Engineers comments for FG/120/12

APPLICATION FG/120/12/

Site Address: The Old Barn Ferringham Lane Ferring BN12 5LL

Description of Works: Amendments to previous approval FG/6/12/ for change of use of the Old Barn, Annexe building & warehouse from retail (A1 Shops) to 2 no. 3 bed residential dwellings (C3 Dwelling

NOTES :		
DATE	REV.	COMMENTS
10-10-12	A	Planning issue

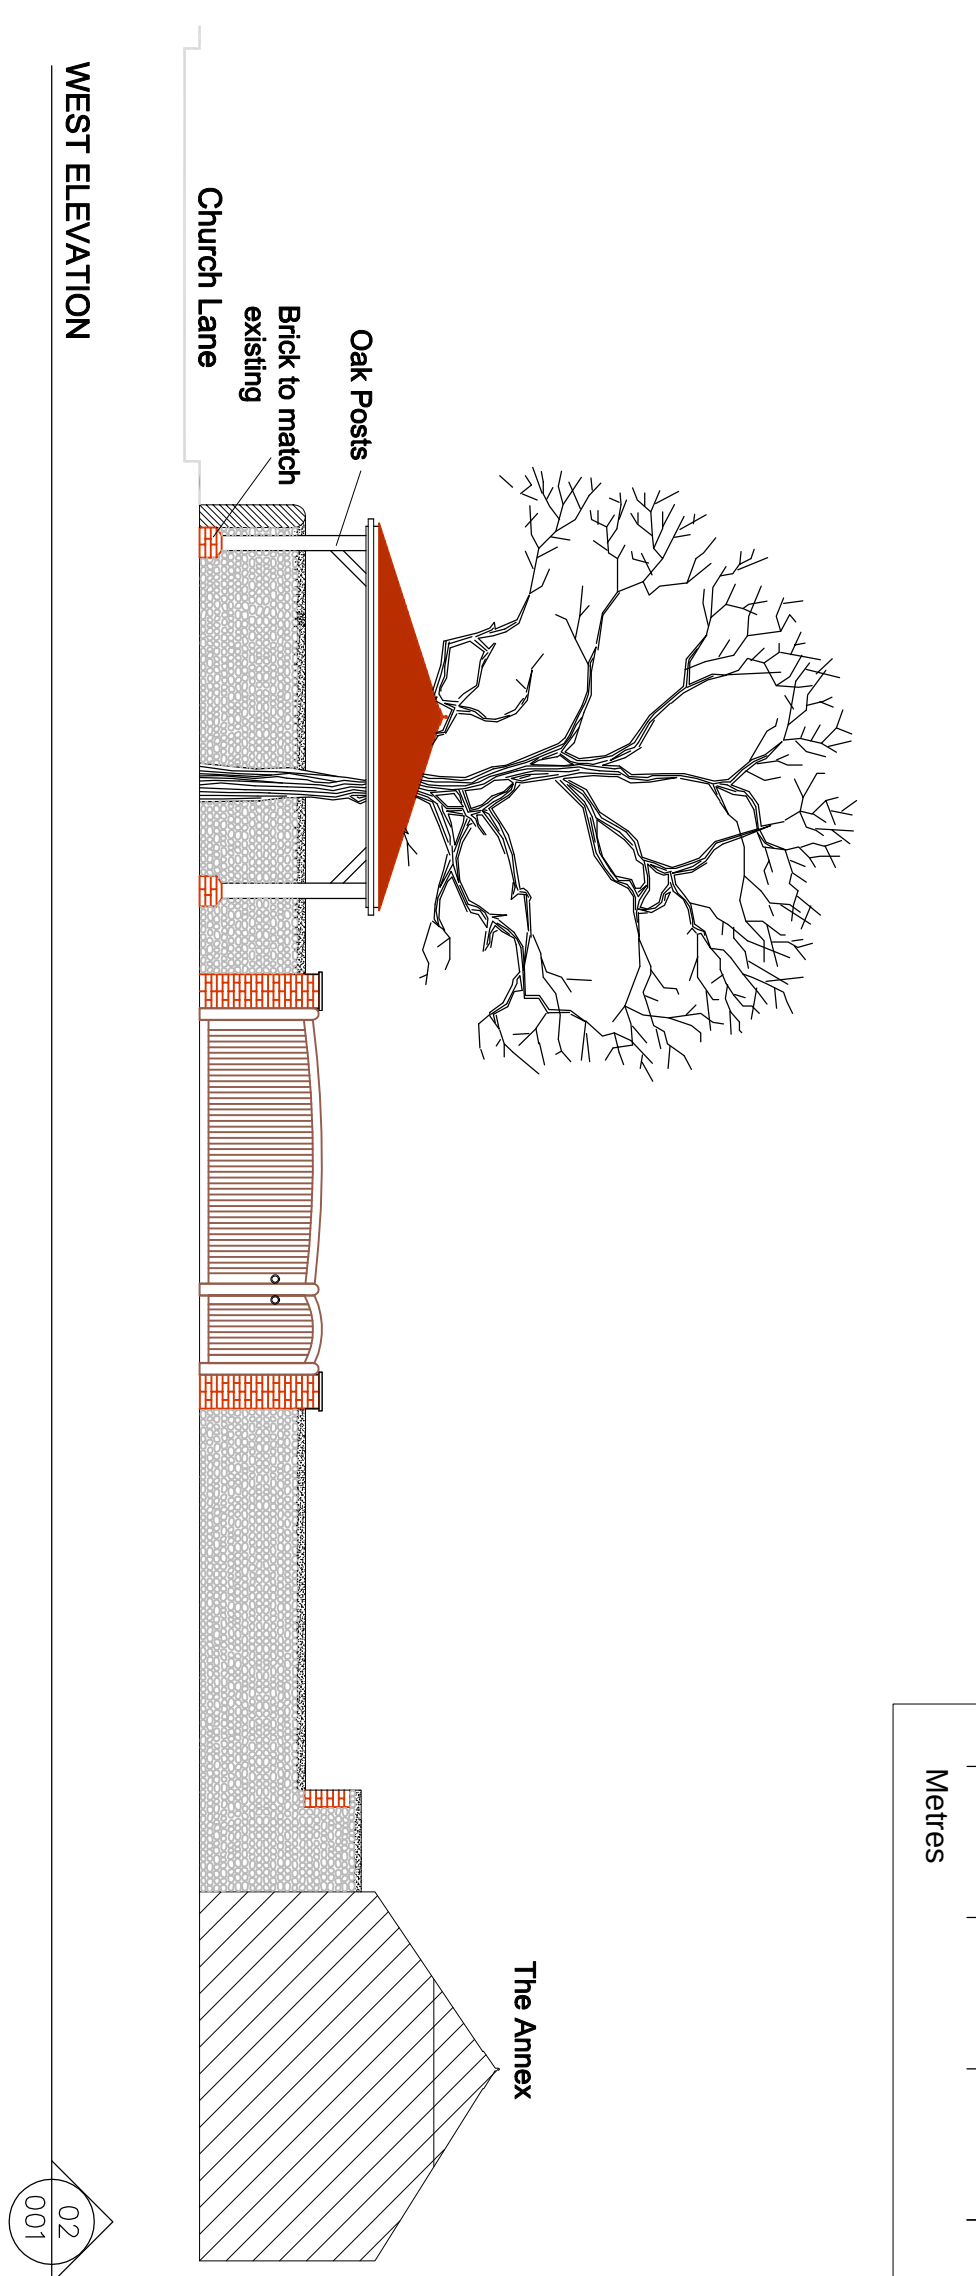
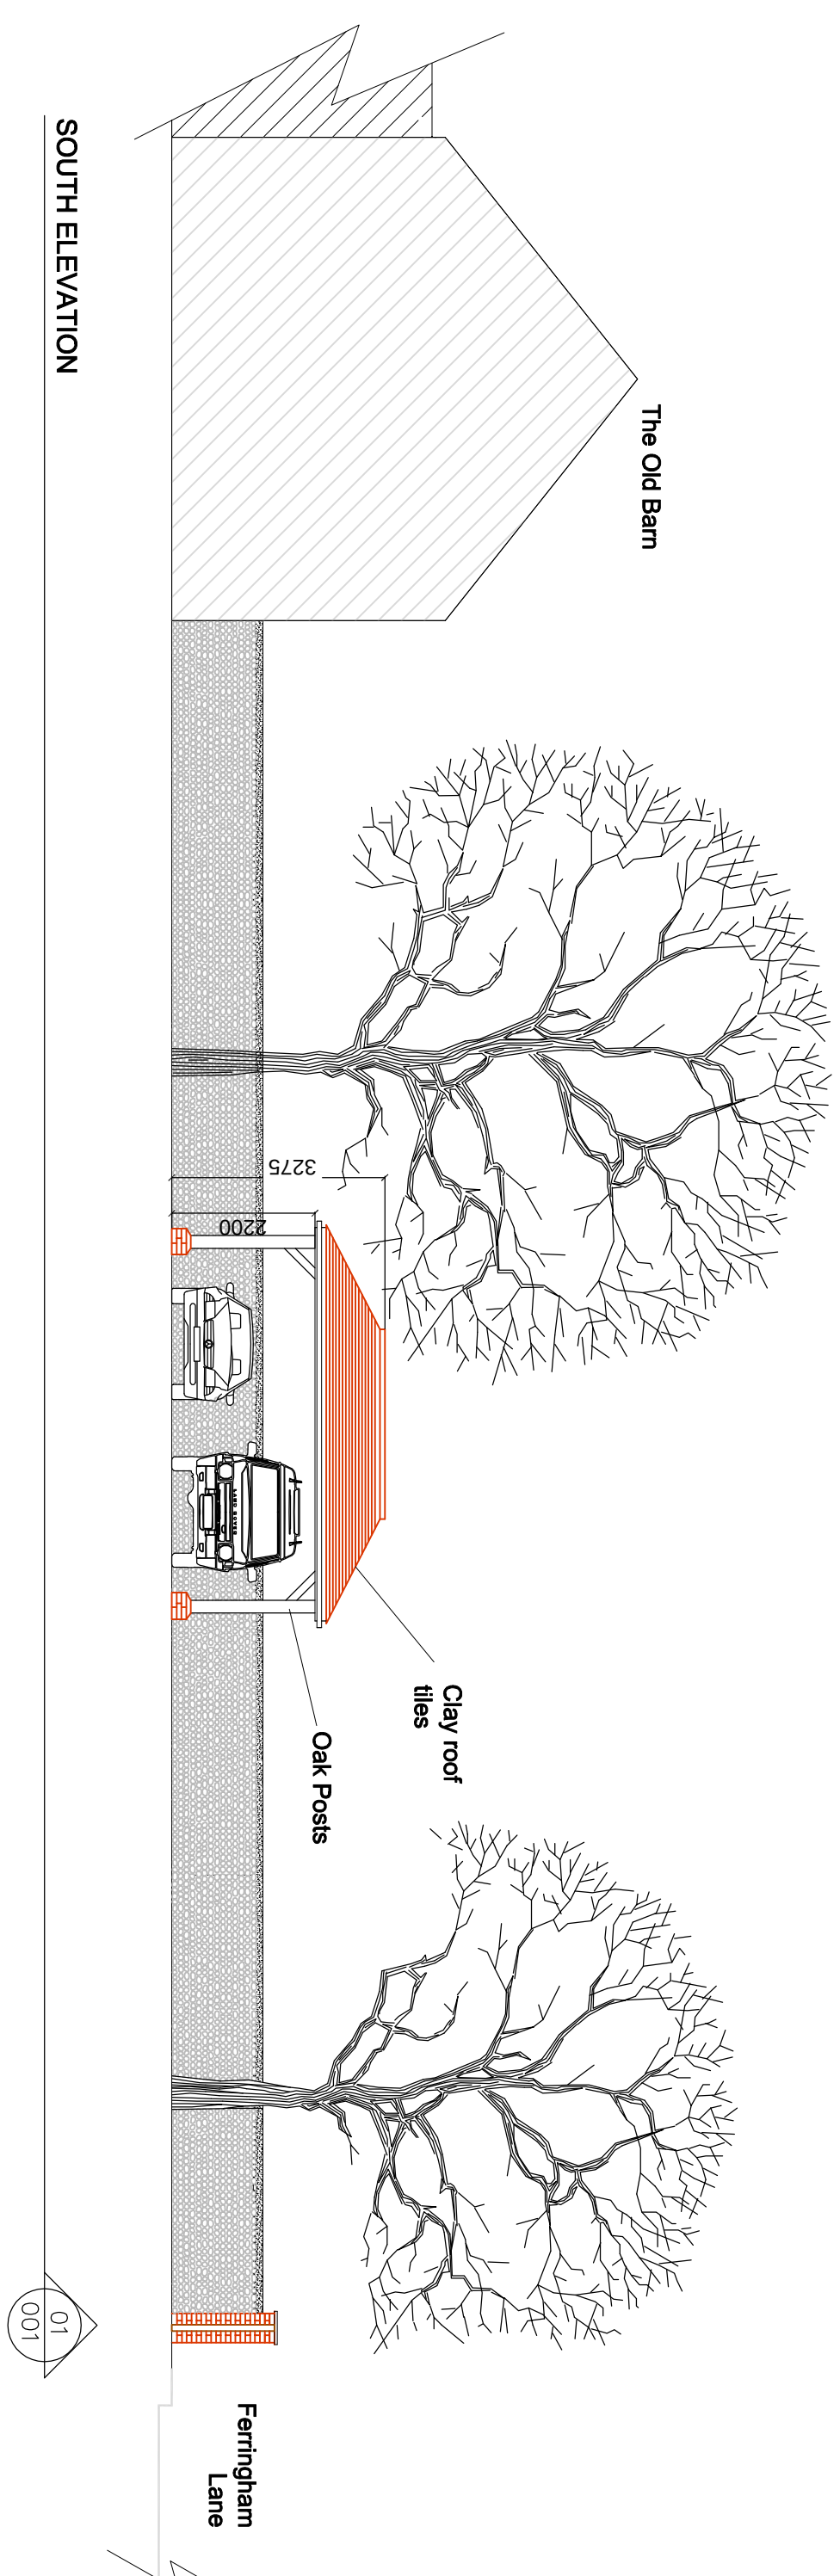
The car shelter will require drainage designs to be submitted please apply the following condition:

Development shall not commence until full details of the proposed surface water drainage scheme for the car shelter have been submitted to and approved in writing by the Local Planning Authority. The design should follow the hierarchy of preference for different types of surface water drainage disposal systems as set out in Approved Document H of the Building Regulations and the SUDS Manual produced by CIRIA. Groundwater monitoring to establish highest annual ground water levels and Percolation testing to BRE 365, or similar approved, will be required to support the design of any Infiltration drainage.
